Application for a non-material amendment following a grant of planning permission.

Demolition of existing garage and extension. Extensions and renovation of existing property including raising of existing ridge height, dormer windows to front and rear elevations and a two storey rear extension.

Reference number:	FG/88/20/HH
Date of decision	29/09/2020

Amendment to proposed external wall materials.
Some walls previously indicated as being finished with white render are now proposed to be finished with Cedral lap cladding in white (C01)

Side Elevation (north)

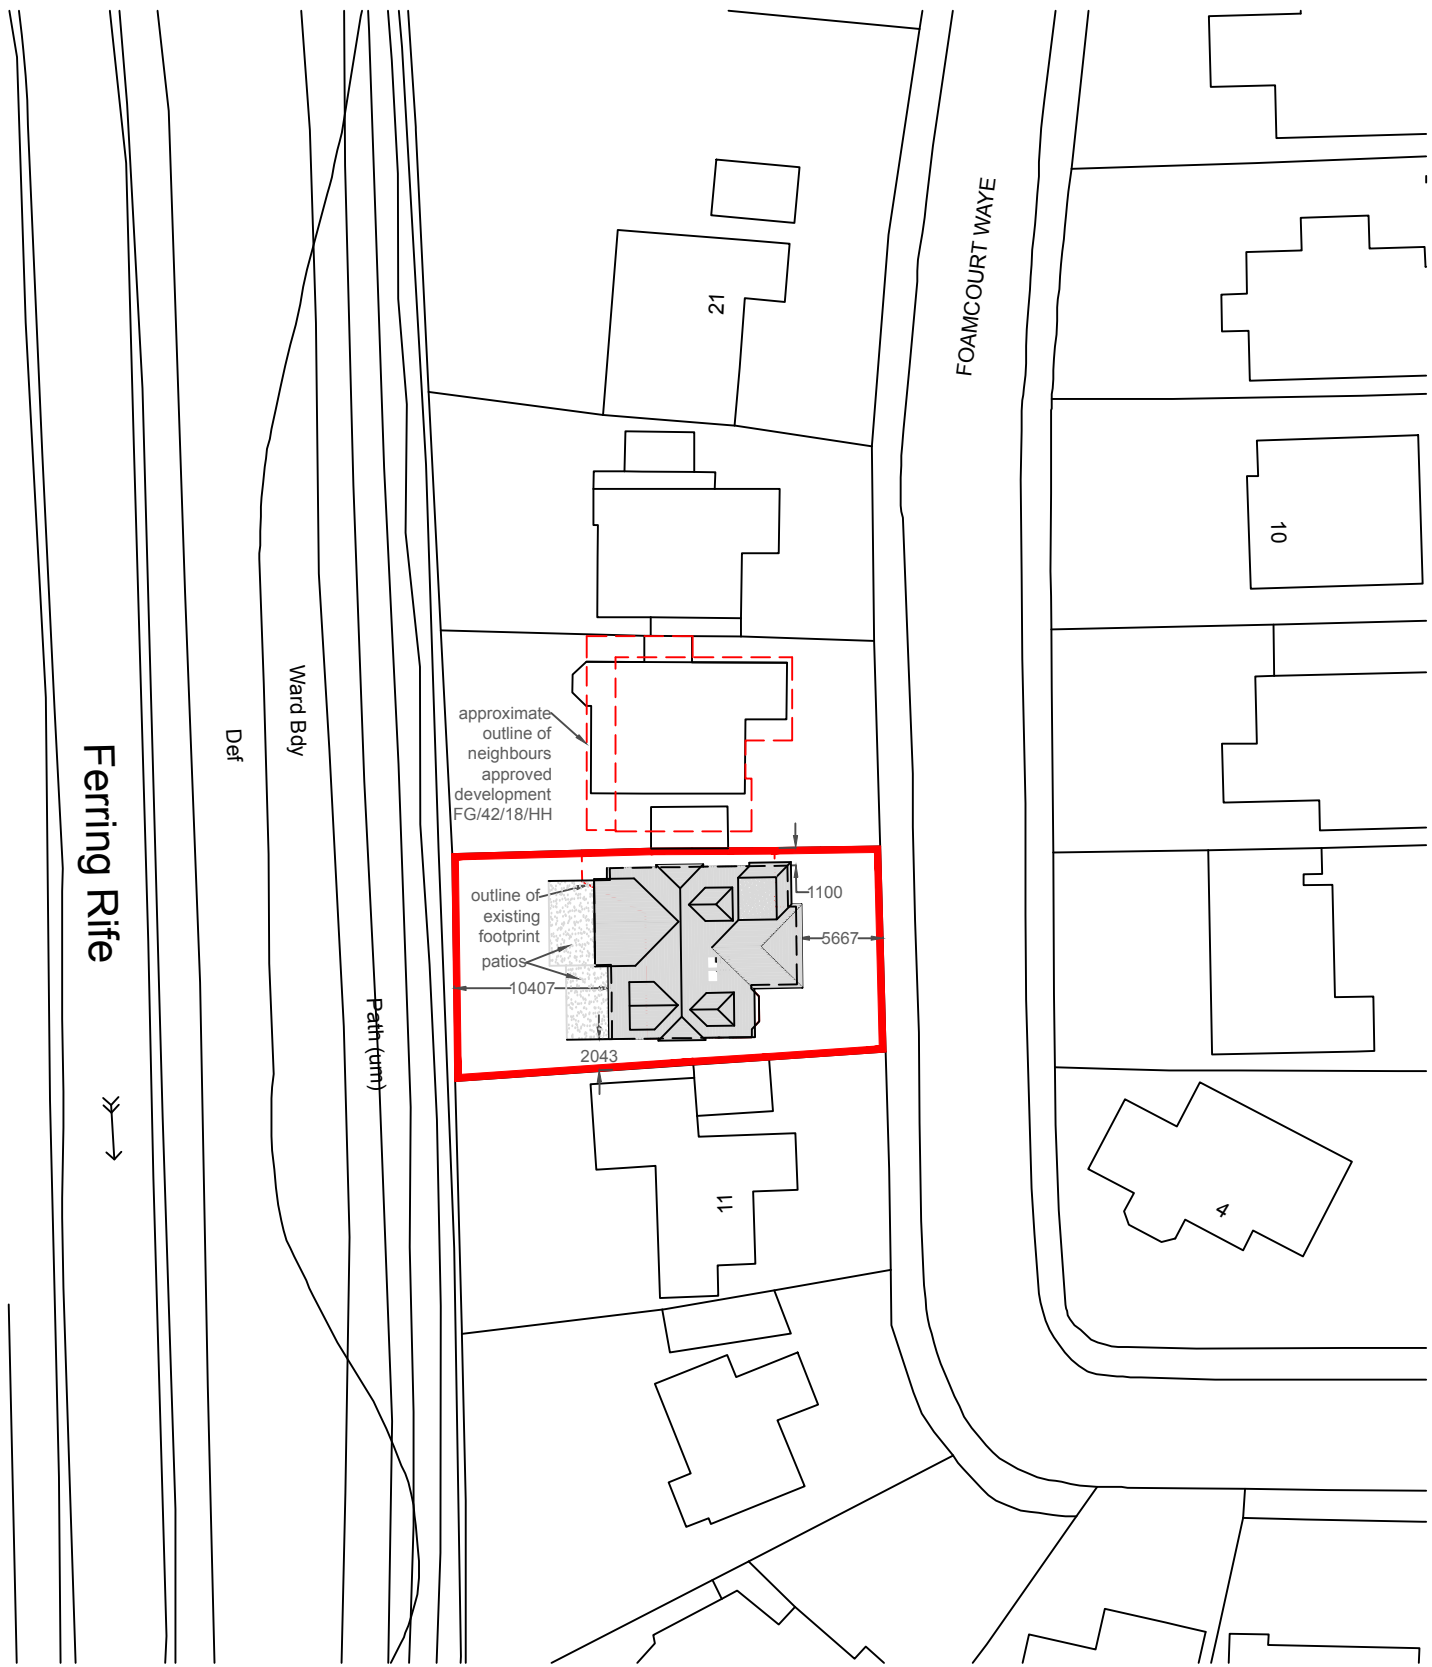
Old plan/drawing numbers

Proposed 1248.02.b

New plan/drawing numbers

Proposed 1248.02.c
